State of Washington
DEPARTMENT OF FISH AND WILDLIFE

SUBJECT: WDFW COMMENTS ON CU-20-00005 HIDDEN POINT

Thank you for the opportunity to comment on the CU-21-00002 Sweetwater Ranch application concerning the construction of an event center on Charlton Road near Naneum Creek (“the project”). Washington Department of Fish and Wildlife (WDFW) has reviewed the application and supporting documents. Our comments are regarding the project’s impact on priority fish and wildlife habitats, particularly shrubsteppe and riparian habitats.

# SITE PLAN

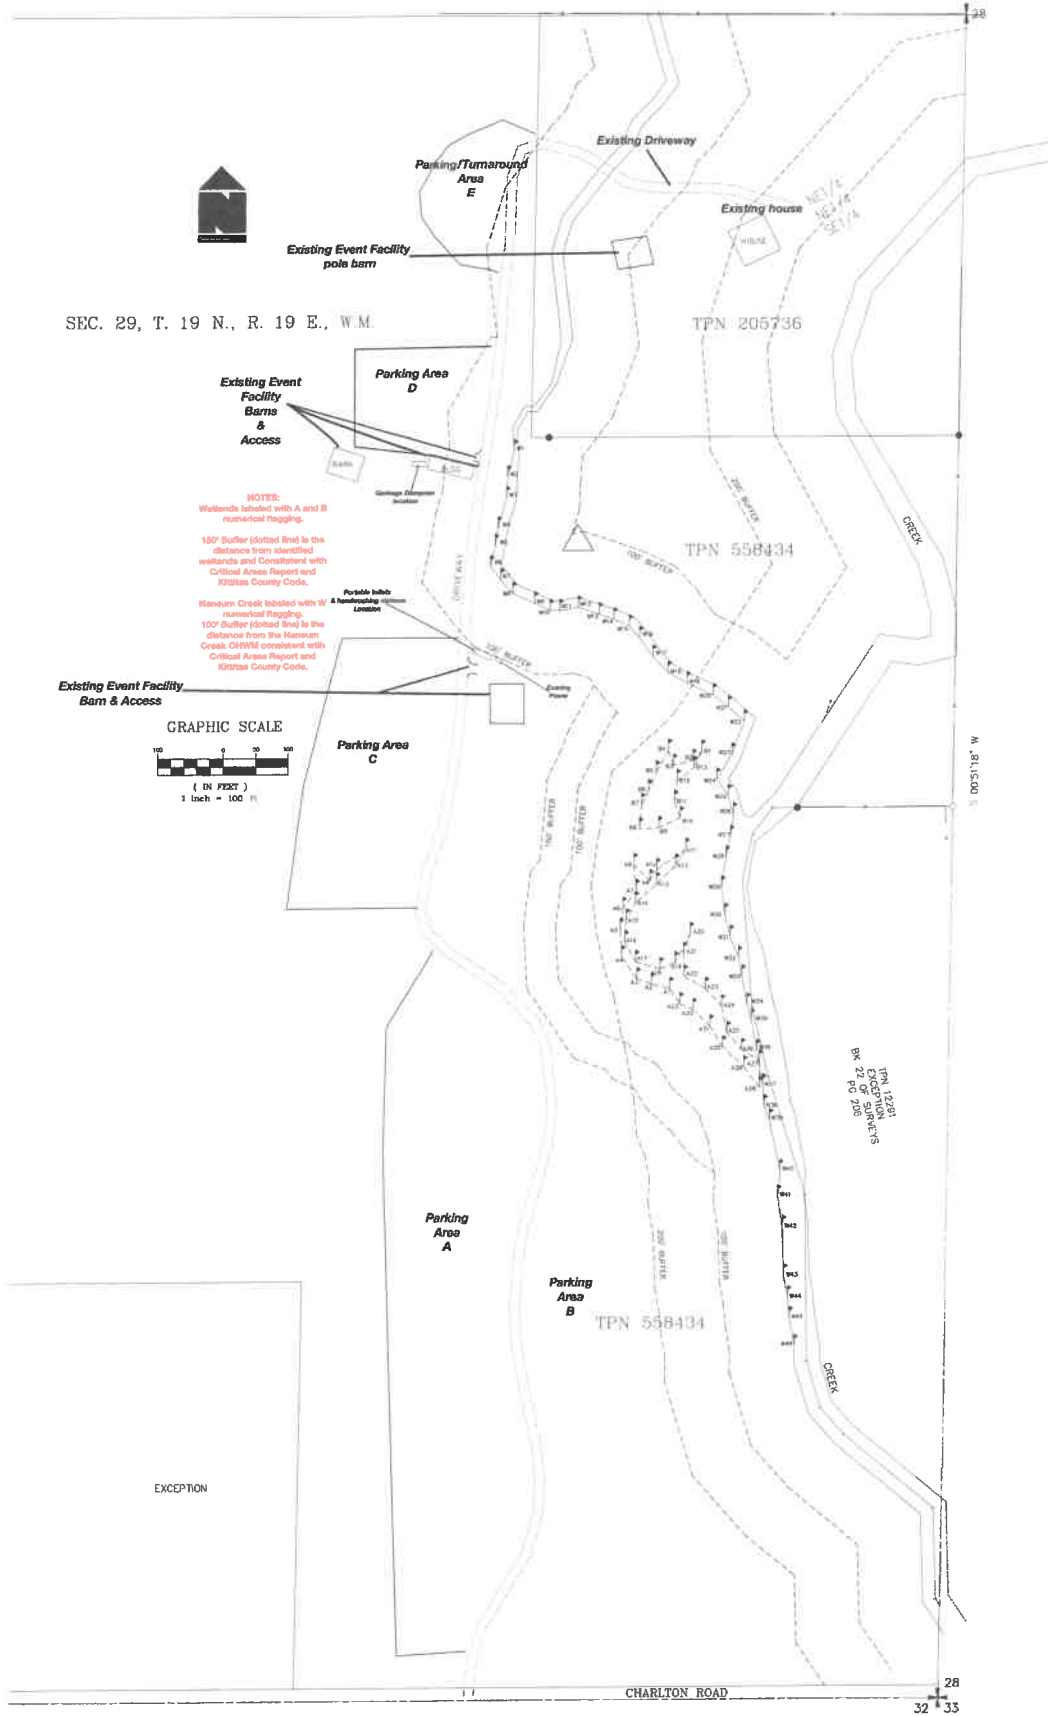
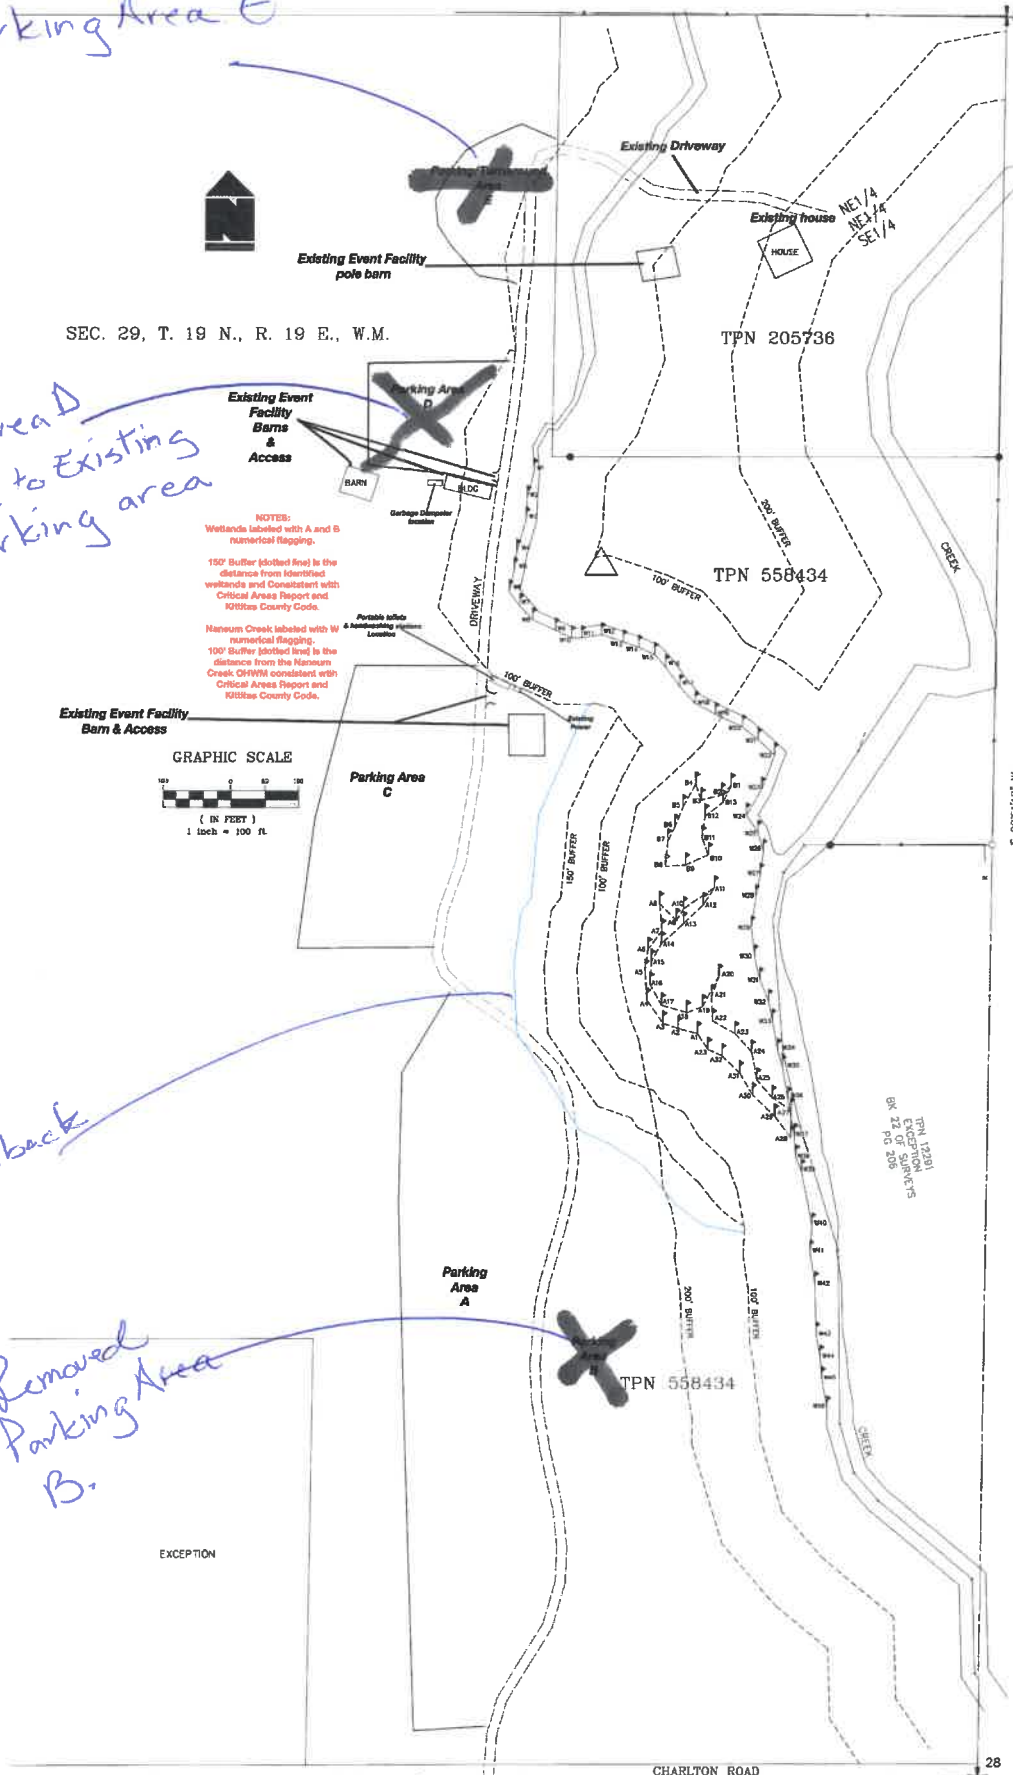
The proposed parking areas, particularly Parking Area D and E (and potentially C depending on the extent) are within priority shrubsteppe habitat and converting these areas to a parking area would result in loss of shrubsteppe habitat through clearing. Further, from aerial imagery there appears to be a drainage with some riparian vegetation going through these proposed parking areas that would be impacted. It is stated in the critical areas report that this is an irrigation ditch, yet no assessment of current habitat quality or function of that area is described. WDFW would like to understand the impacts of that drainage for fish and wildlife habitat. Parking Area B is next to a well vegetated area which the critical areas report identifies as an irrigation ditch. WDFW would like to understand the connection of that ditch to Naneum Creek and the implications of the parking area on the associated habitats here. WDFW requests that these parking areas either be configured to avoid these habitat impacts, or habitat mitigation proposed (such as enhancement of other habitat areas on the property)

to offset these impacts. WDFW would like to meet on site with the applicant and Kittitas County to further discuss the issue of minimization of habitat impacts and/or habitat mitigation.
